Addendum No. 1

RE: Contract ID: C201616

Brunswick County (B-682)

Bridge Over Intercoastal Waterway and
Approaches on SR-1172 at Sunset Beach

SEE SHEET 10 FOR -L- PROFILE
 SEE SHEET 12 FOR -Y1- PROFILE
 SEE SHEET 13 FOR -DET- PROFILE

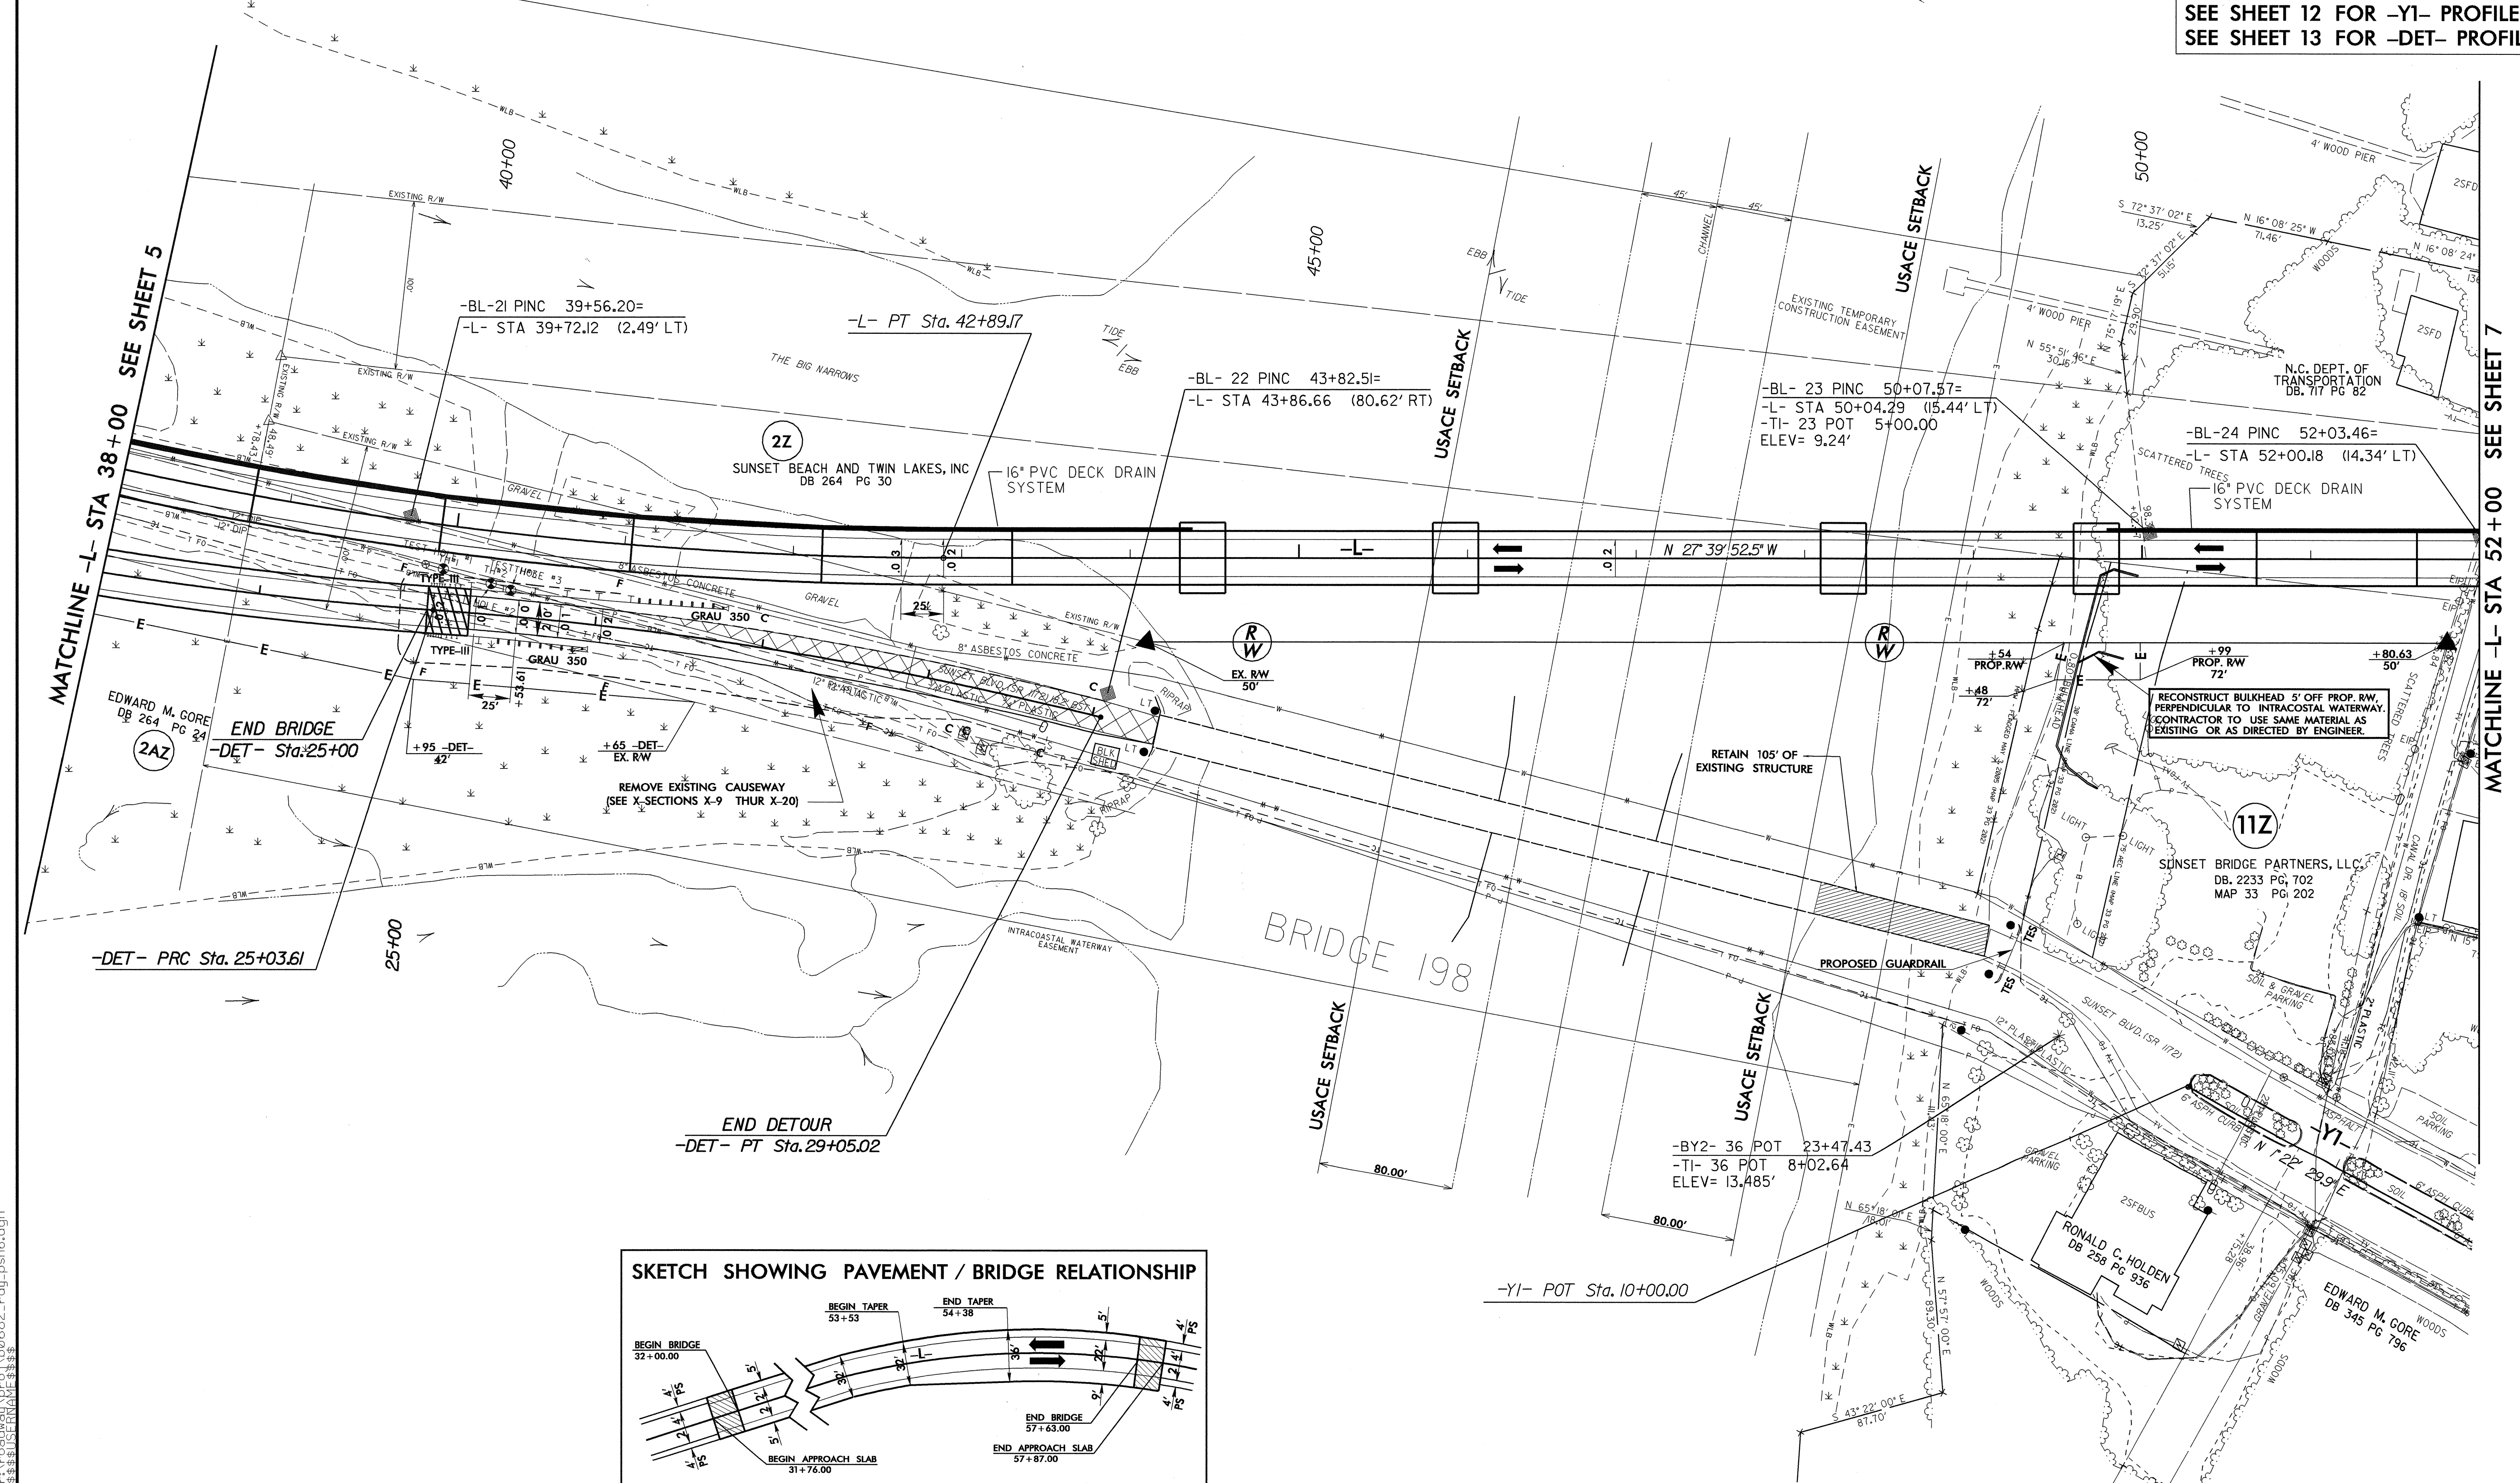
The Contractor's attention is directed to the note on Sheet 6 in the plans and the conditions of the CAMA permit regarding bulkhead reconstruction. The existing portion of the bulkhead within the R/W shall be removed and disposed of by the Contractor. The reconstructed portion shall consist of material furnished by the Contractor, which is the same type material as the existing bulkhead, as approved by the Engineer. No direct payment will be made for removal and disposal of this portion of the existing bulkhead or for reconstructing the portion required, as the cost of same shall be included in the Lump Sum price bid for "Clearing and Grubbing". Such price and payment will be considered full compensation for removing and disposing the required portion of the existing bulkhead, for furnishing materials for bulkhead reconstruction, and for all labor, materials, equipment and incidentals necessary to complete the work.
